Re: **I-Joist Issue**
Location: Lot 63 Serenity (Contentment Lane Fuquay-Varina, NC)
JDS Project No.: RDU2305408
Date of Inspection: 06/30/2023

A representative of JDS Consulting arrived on site to observe the issues reported to us by the client, which are presented, along with our recommendations, in this report.

**2.02F**  
Second Floor Framing Plan  
Elevation "B"

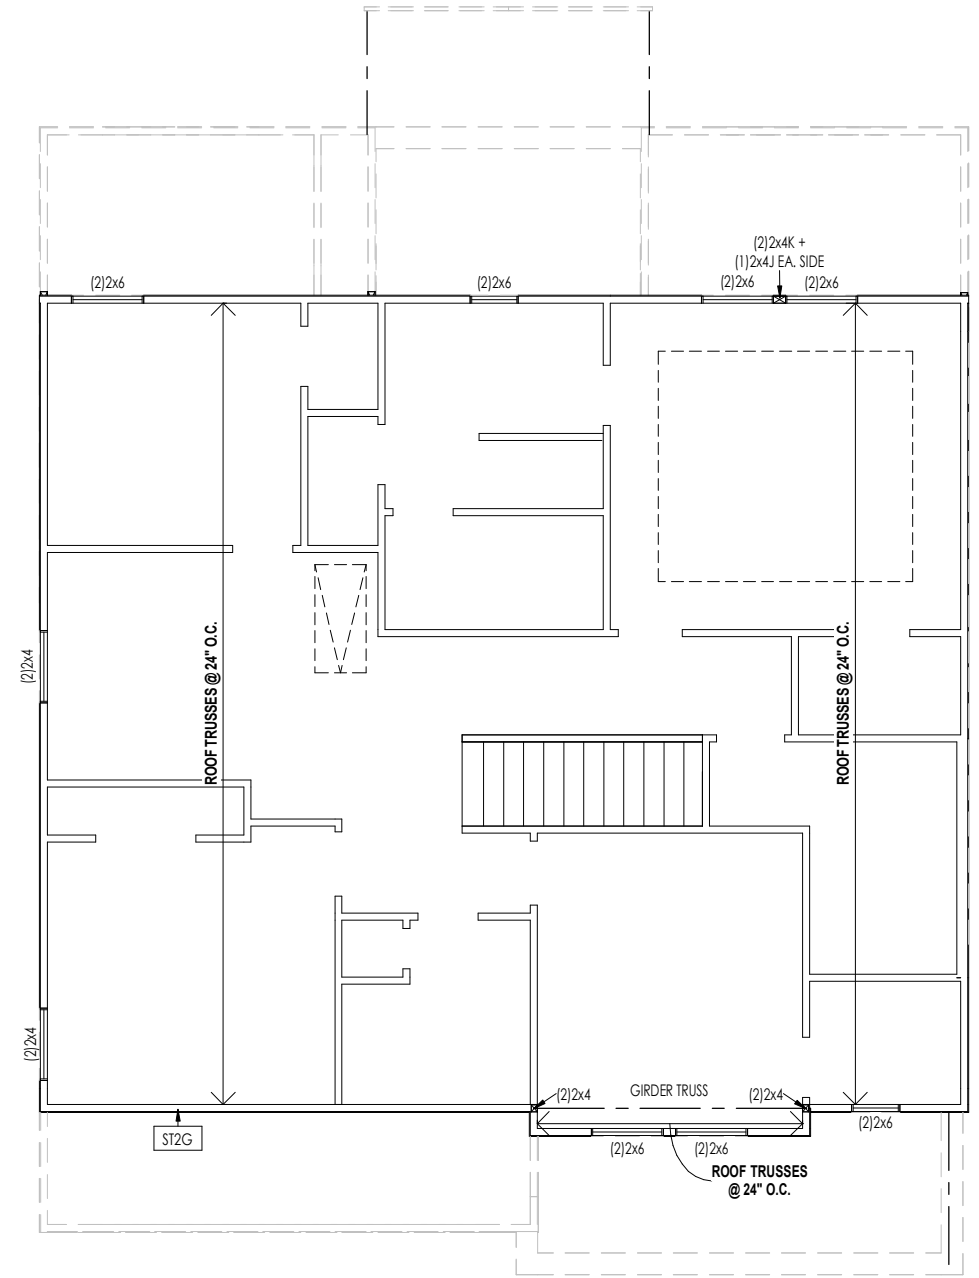
Between the 7th and 8th 2nd floor joists from the left wall above the garage an extra joist is called for and none has been installed.

Based on our onsite observations and review, install 2x4 ladder frame blocking at 24" o.c. between the 7th and 8th joist from the left wall. Attach the ladder frame blocking with (2) 10D toenails at each side into the top flanges.
